From: Martyn White
Sent: 30 August 2019 10:24
To: Planning.Responses <Planning.Responses@arun.gov.uk>
Cc: Anita Gardner <Anita.Gardner@arun.gov.uk>
Subject: CM/42/19/PL & CM/43/19/L

CM/42/19/PL & CM/43/19/L

This application relates to Mill thatch, which is located roughly to the south of the Mill and is a curtilage listed structure.

Detail of Pocket Sliding Door and Overlay Sliding Shutter

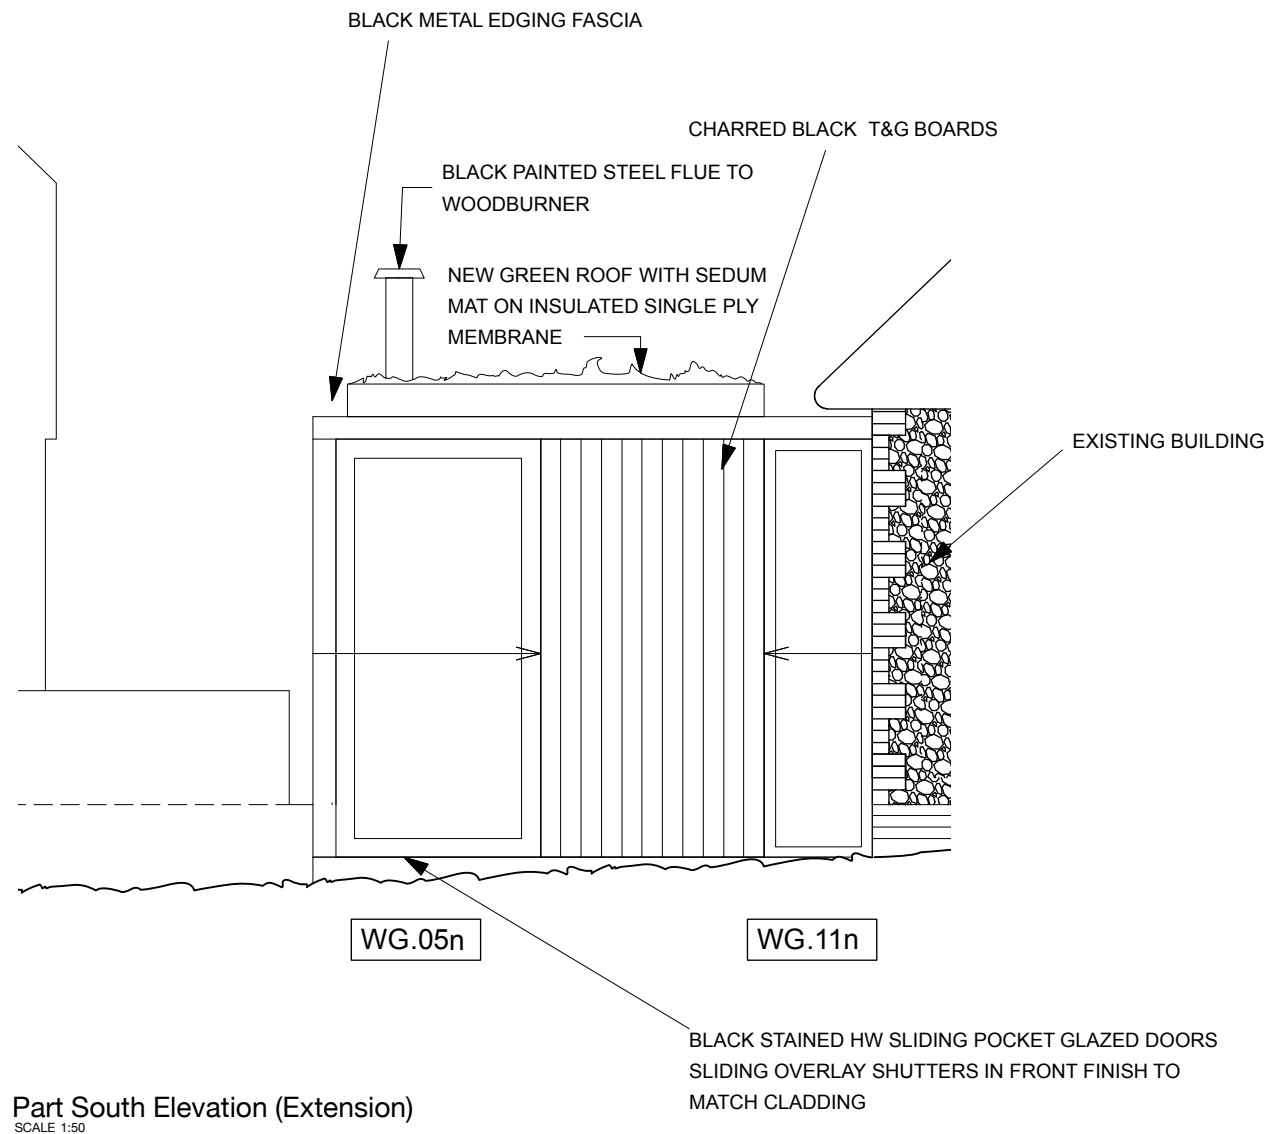
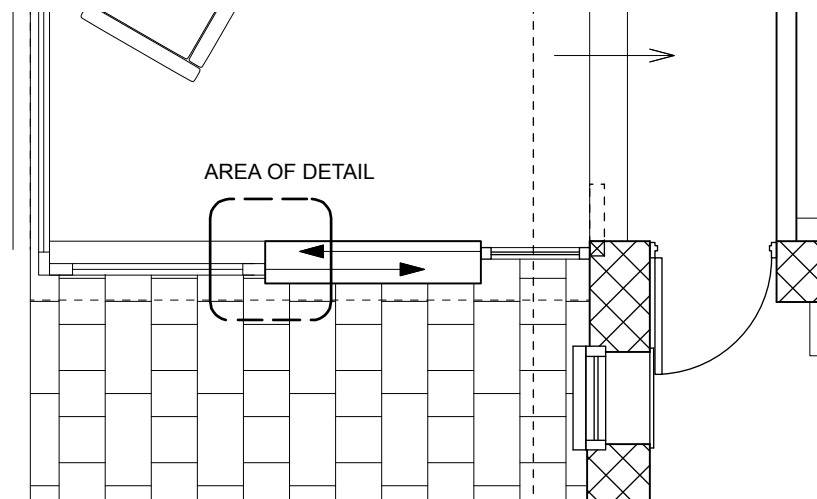
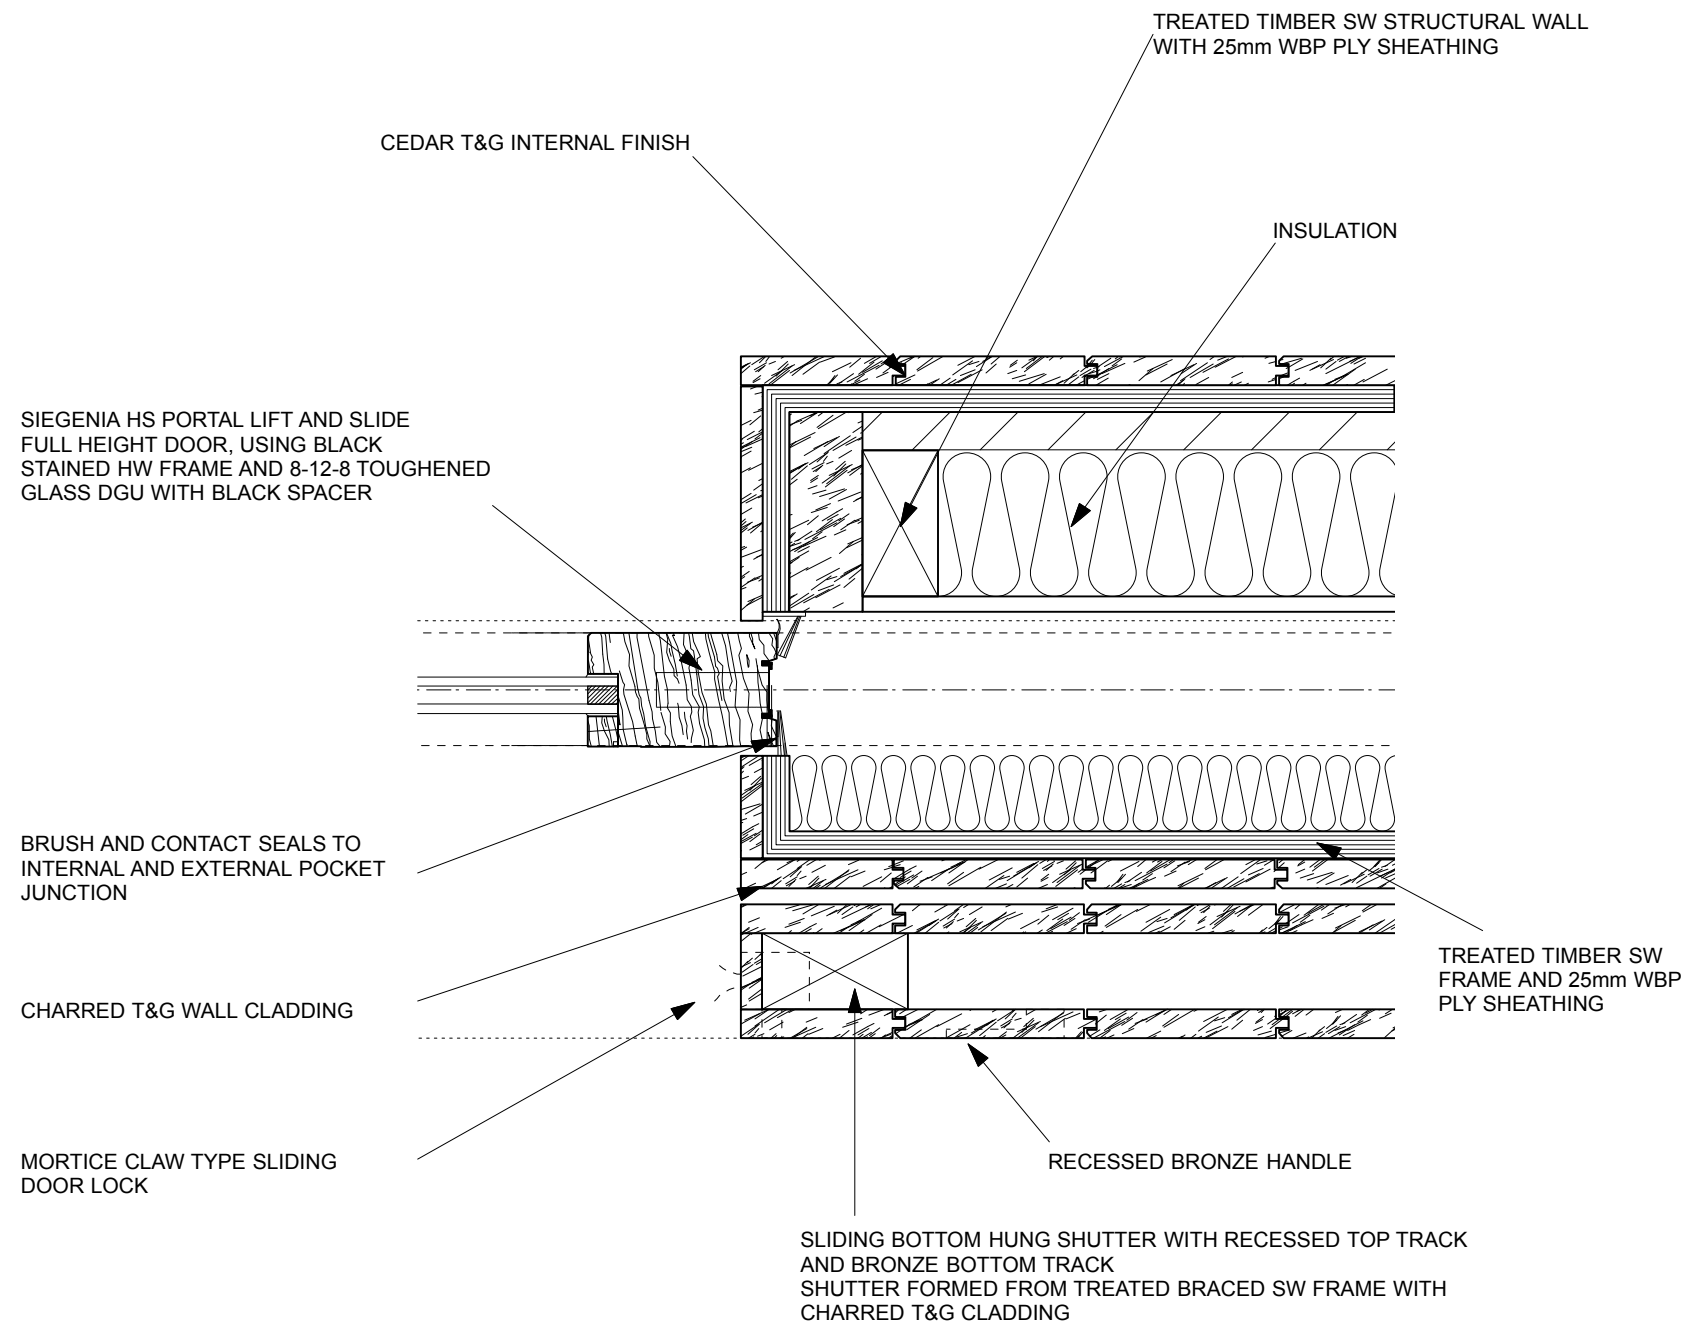
As noted within the revised statement, the proposals include shutters to be added to all glazed windows and doors to provide improved security and climatic protection. Historic photos are referenced as an argument for the case. However, it is not clear from the elevations that all of the windows and doors will have shutters. For instance reference is made to their existence for windows 3 and 4 on the floor plans, but not the elevations. It is not clear how they will function, or look with the proposed openings. Likewise reference is made to bi-folding shutters to window number 8 on the elevation, but it is not clear what they will look like?
